TEXAS TURNPIKE AUTHORITY SUPPLEMENTAL AGREEMENT FOR EXTRA WORK. PROJECT: Addison Airport Tunnel. DATE: 7/27/97. SHEET NO. 1 OF 1. CONTRACT NO. DNT-260. H.B. Zachry Company (CONTRACTOR). PO Box 531558, Grand Prairie, TX 75053. (ADDRESS). AGREEMENT SHALL PERTAIN TO ONLY ONE CONTRACT AND SHALL BE NUMBERED CONSECUTIVELY FOR EACH CONTRACT. AUTHORIZATION IS HEREBY REQUESTED FOR THE PERFORMANCE OF EXTRA WORK UNDER THE ABOVE CONTRACT DESCRIBED AS FOLLOWS: (ATTACH DRAWING OR SKETCHES WHERE APPLICABLE). (EXPLAIN BELOW IF REQUIRED). H.B. Zachry wishes to enter into an agreement with HDR Engineering to perform the following services: Review the alternate design of Deckwall at DS Type retaining walls. HDR Engineering has agreed to this arrangement for a price not to exceed \$25,000. Review of shop drawings for alternate design of DS Type retaining walls. Geotechnical assistance associated with the alternate design of DS walls. All parties agree that this is a "Value Engineering" change and will result in cost to Texas Turnpike Authority. HDR will invoice Texas Turnpike Authority and the same shall be deducted from monies due H.B. Zachry. The net cost to Texas Turnpike Authority will be \$0.00.

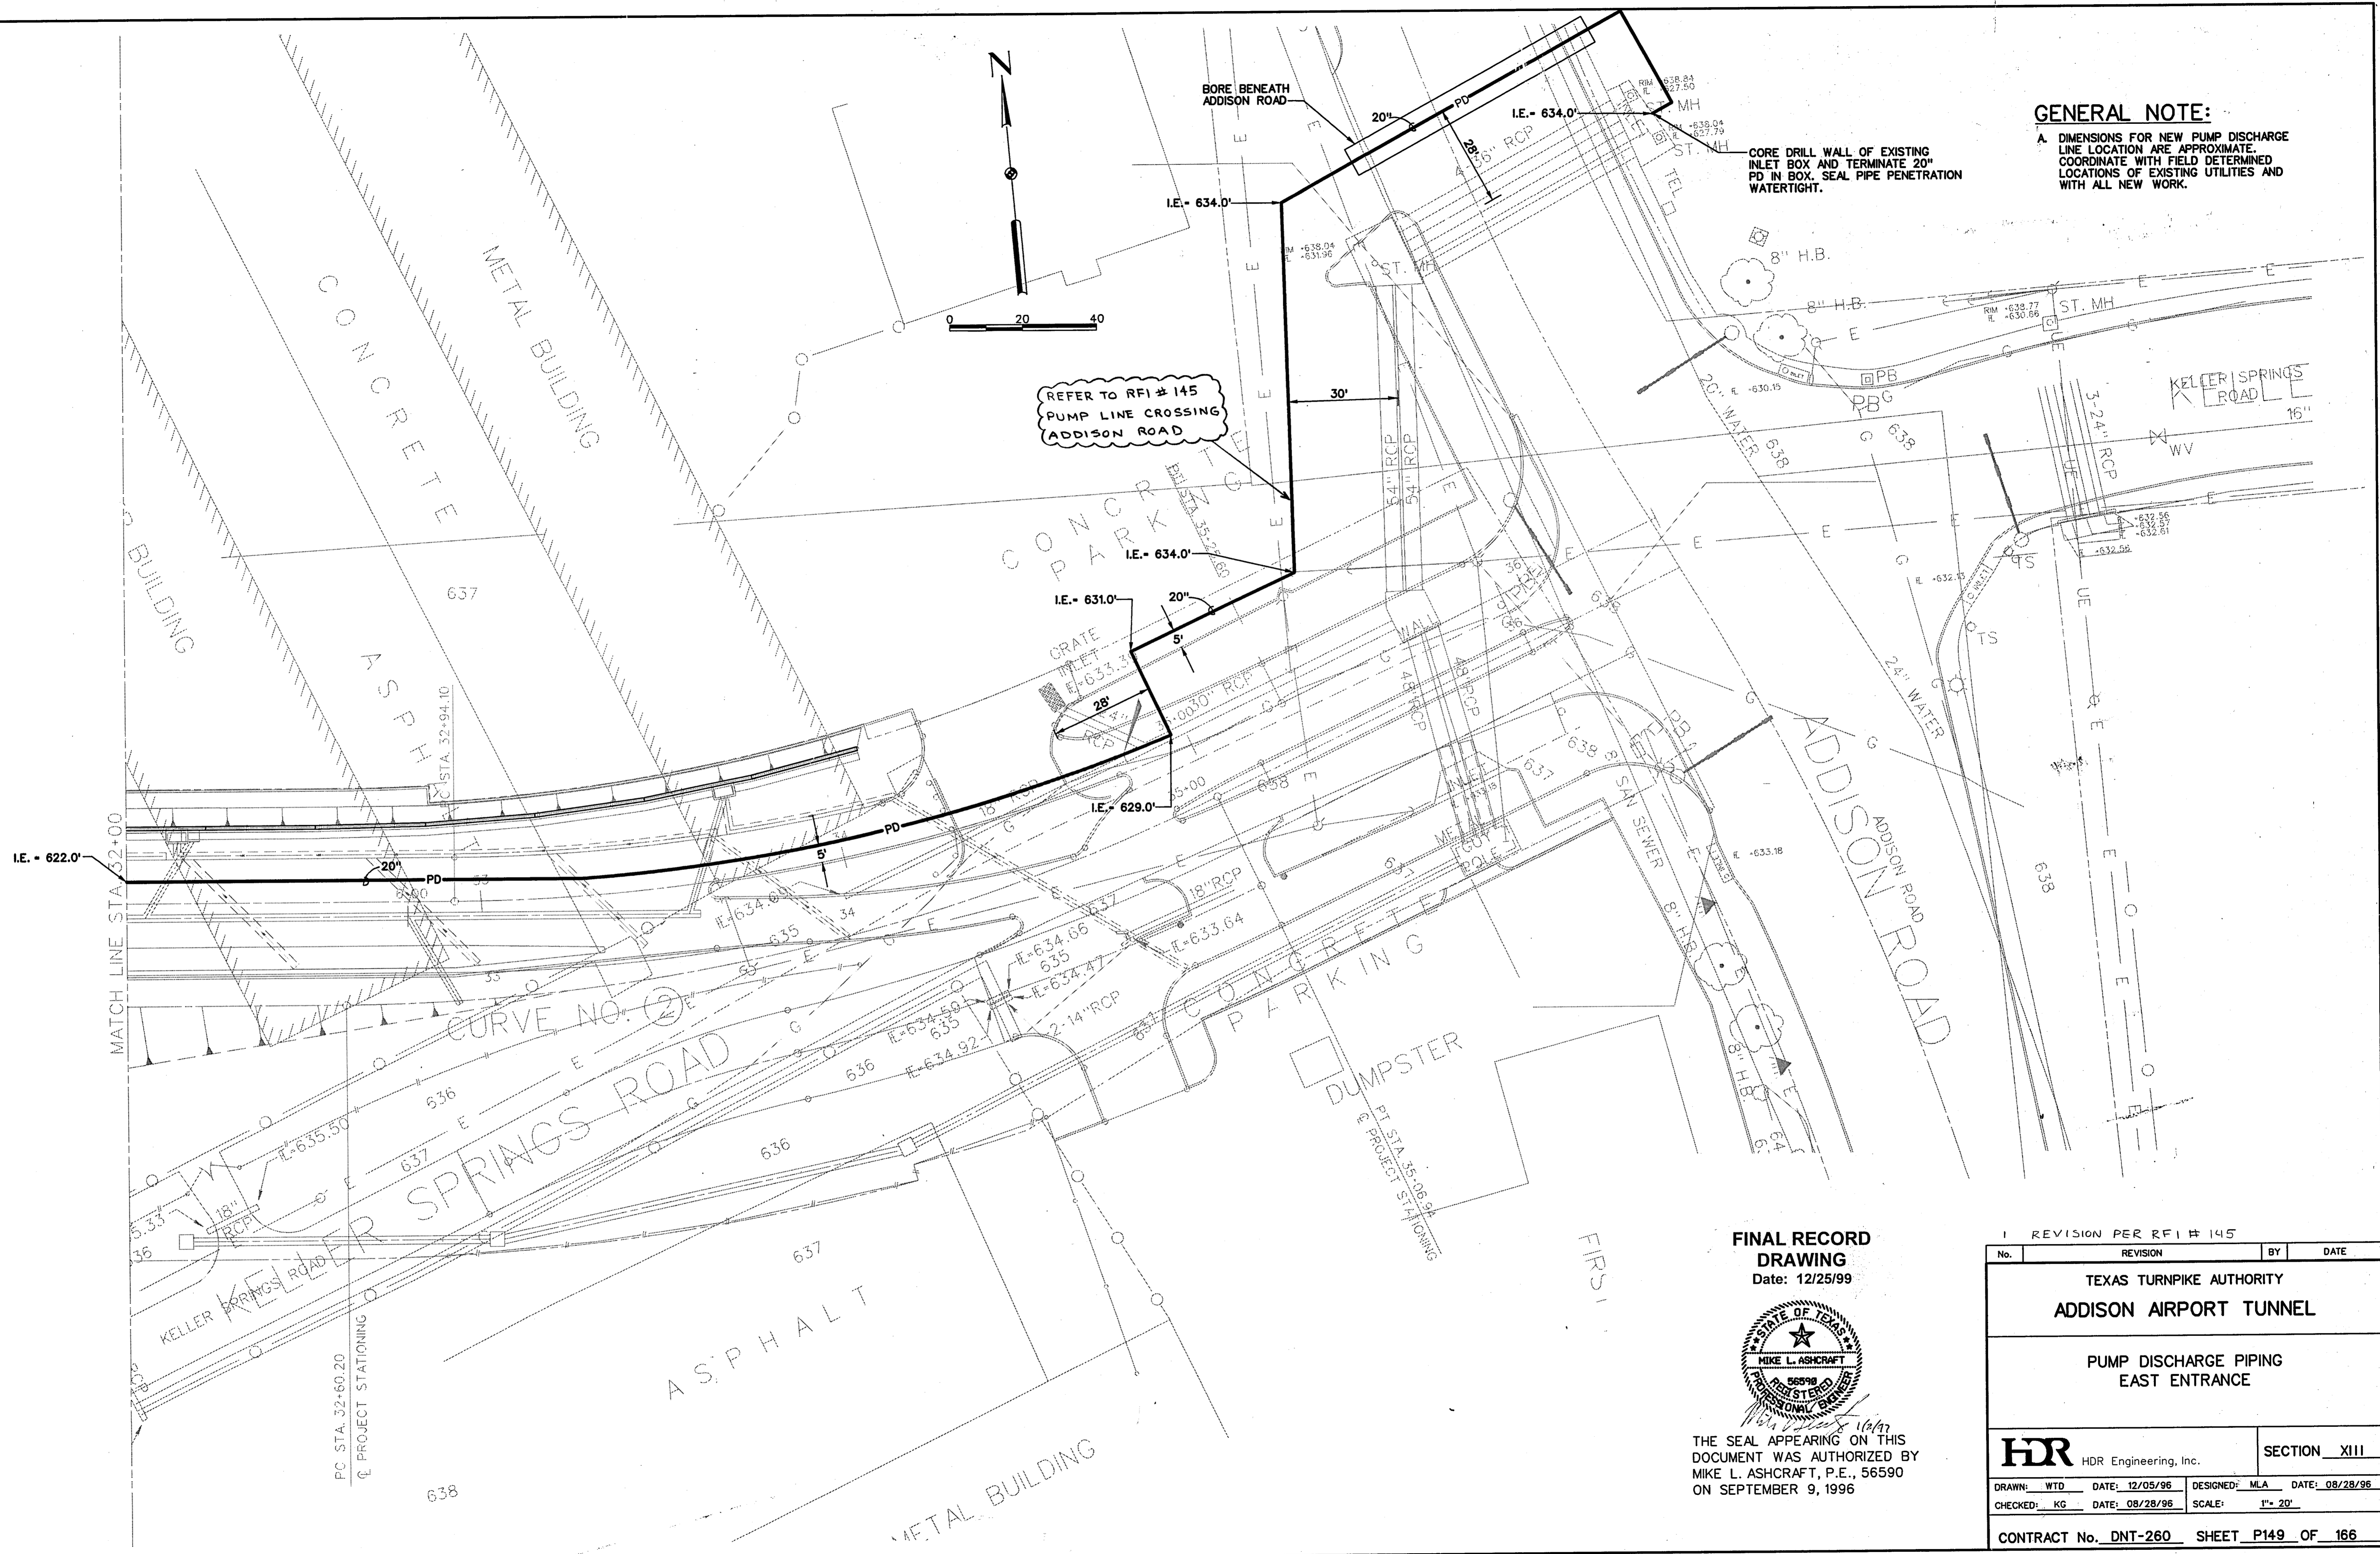
NORTH TEXAS TOLLWAY AUTHORITY SUPPLEMENTAL AGREEMENT FOR EXTRA WORK. PROJECT: Addison Airport Tunnel. DATE: 12/18/97. SHEET NO. 1 OF 1. CONTRACT NO. DNT-260. H.B. Zachry Company (CONTRACTOR). PO Box 531558, Grand Prairie, TX 75053. (ADDRESS). AGREEMENT SHALL PERTAIN TO ONLY ONE CONTRACT AND SHALL BE NUMBERED CONSECUTIVELY FOR EACH CONTRACT. AUTHORIZATION IS HEREBY REQUESTED FOR THE PERFORMANCE OF EXTRA WORK UNDER THE ABOVE CONTRACT DESCRIBED AS FOLLOWS: (ATTACH DRAWING OR SKETCHES WHERE APPLICABLE). (EXPLAIN BELOW IF REQUIRED). This supplemental agreement is necessary to remove 20" discharge pipe from the tunnel sum to prevent the shut down of Longhorn Sports Bar. The original location would have required additional easements that are not now available. 1) 40" section 20' box @ 400 SF = \$19,803.00 2) 80" additional depth (now located in rock) @ 72.45 = \$7,390.00 3) Additional depth for shoring for rock & retaining pile = \$7,390.00 4) All work necessary to connect the front bored pile to existing pile to junction box including & replacing sand, asphalt pavement, curbs, all pipe, fittings etc. to complete the connection. Also includes protection of existing utilities. Contractor makes no guarantee that the tree roots in the area will not be damaged. \$26,829.39 5) Restock of unused 20" PVC pipe = \$518.00 6) 40" section 20' box @ 400 SF = \$19,803.00 7) Deduct item 1502-6 - 20" PVC pump discharge pipe 157 LF @ 96.00 = (\$15,072.00) Total This Agreement = \$45,924.39
